Cowfold Rampion Responses to Local Impact Reports Deadline 2

Comments on REP1-044 Horsham District Council Local Impact Reports:

Service Layer Credits: Contains OS data © Crown Copyright and database right 2020

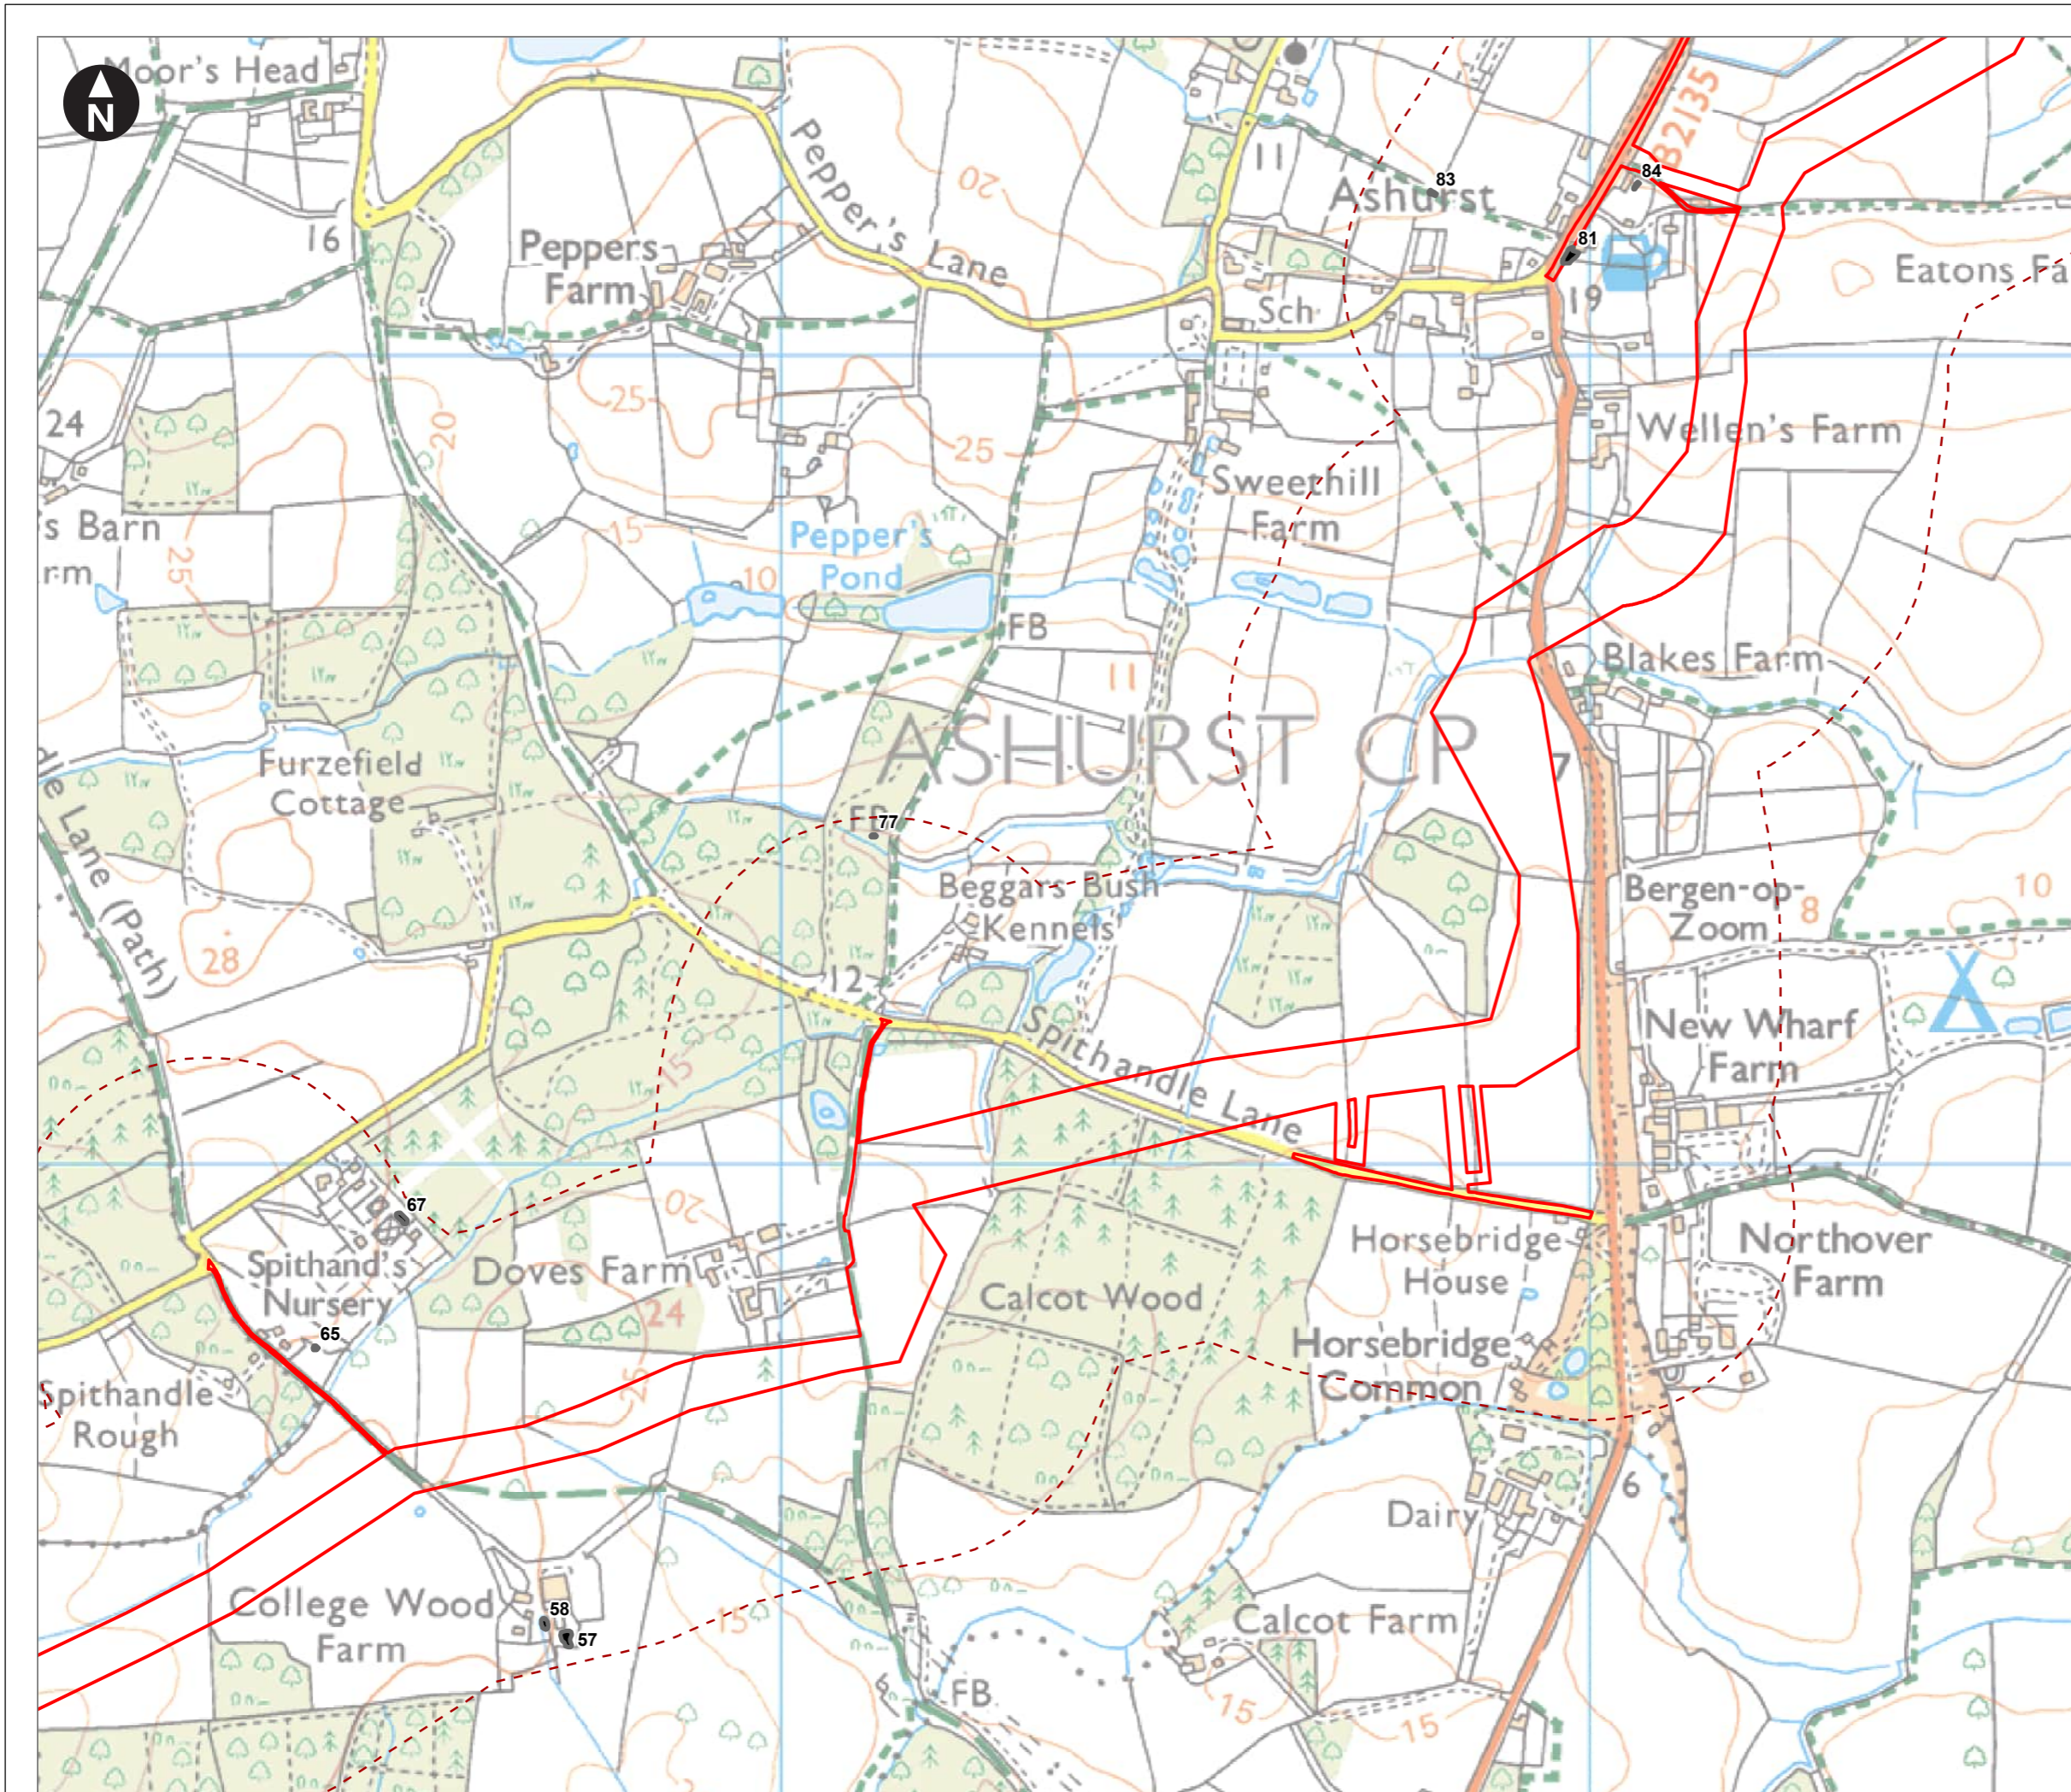
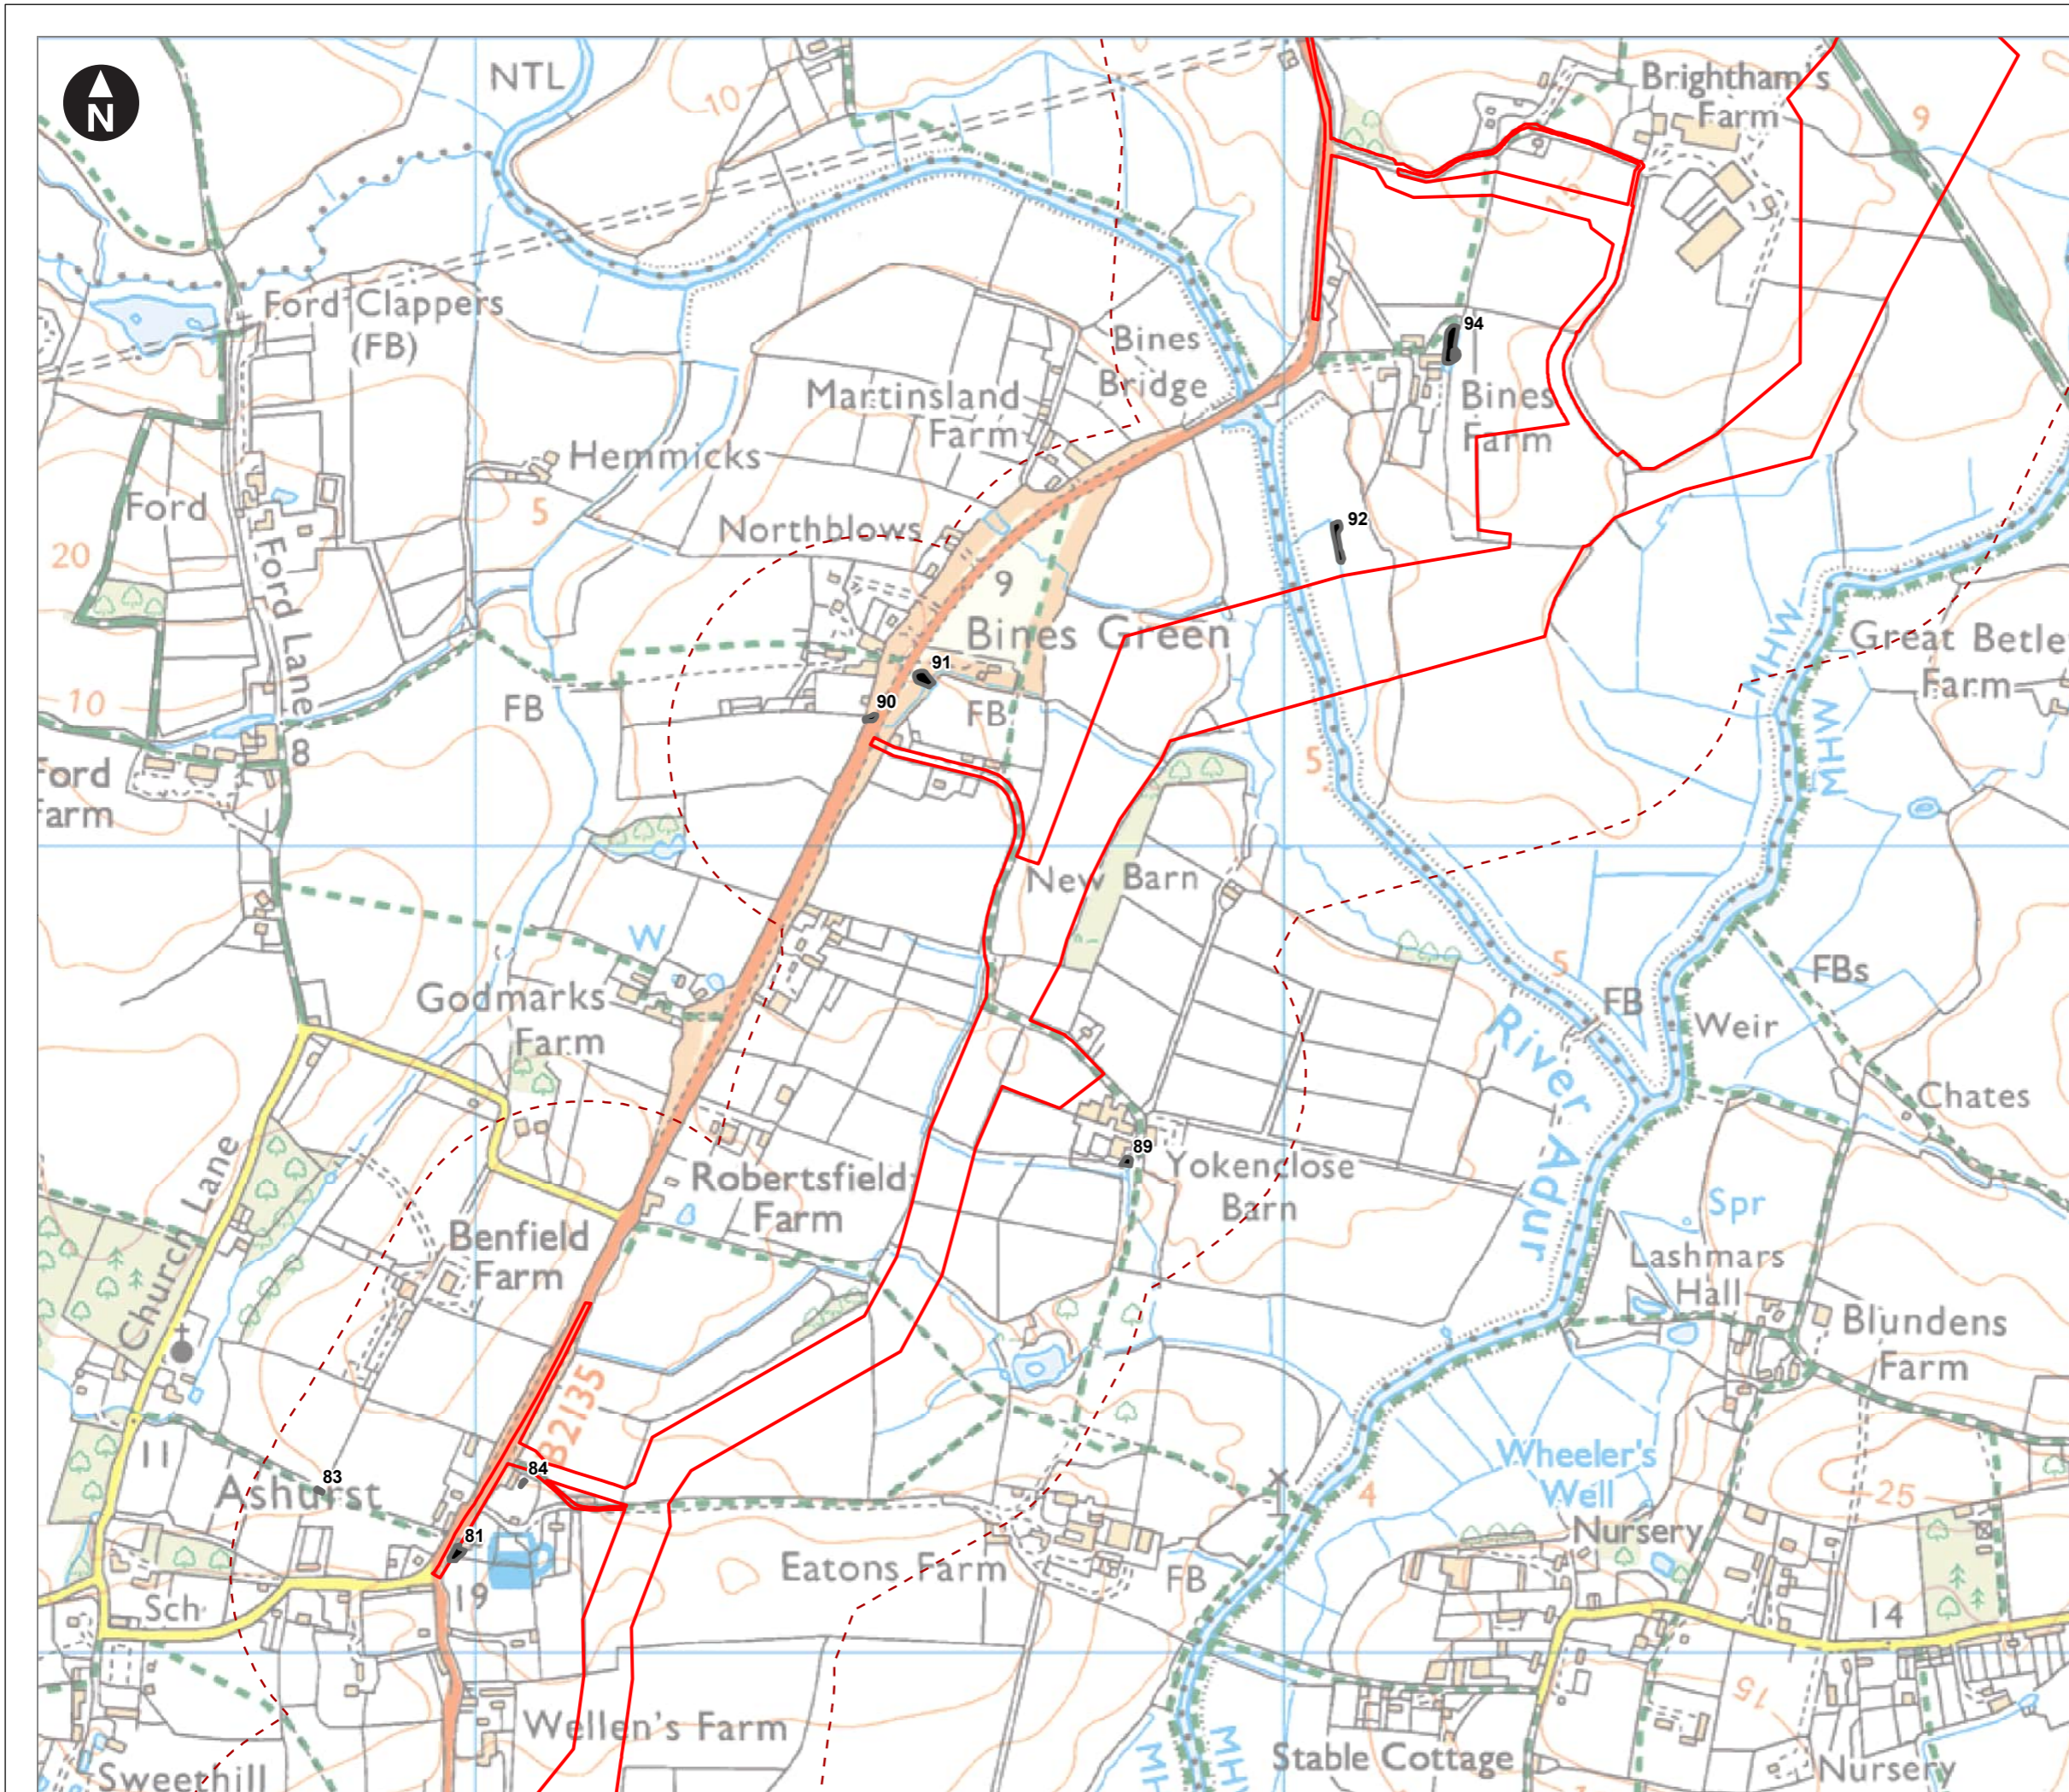
3.1) CowfoldvRampion endorses Horsham DC’s concerns but would like to add that the sites chosen for meadowland survey also do not reflect the most valuable meadowlands. The newt ponds and survey dates are already available; they show a high proportion of ponds in this area were either not surveyed as they were ‘inaccessible’, or were surveyed outside prime months, or DNA was degraded.
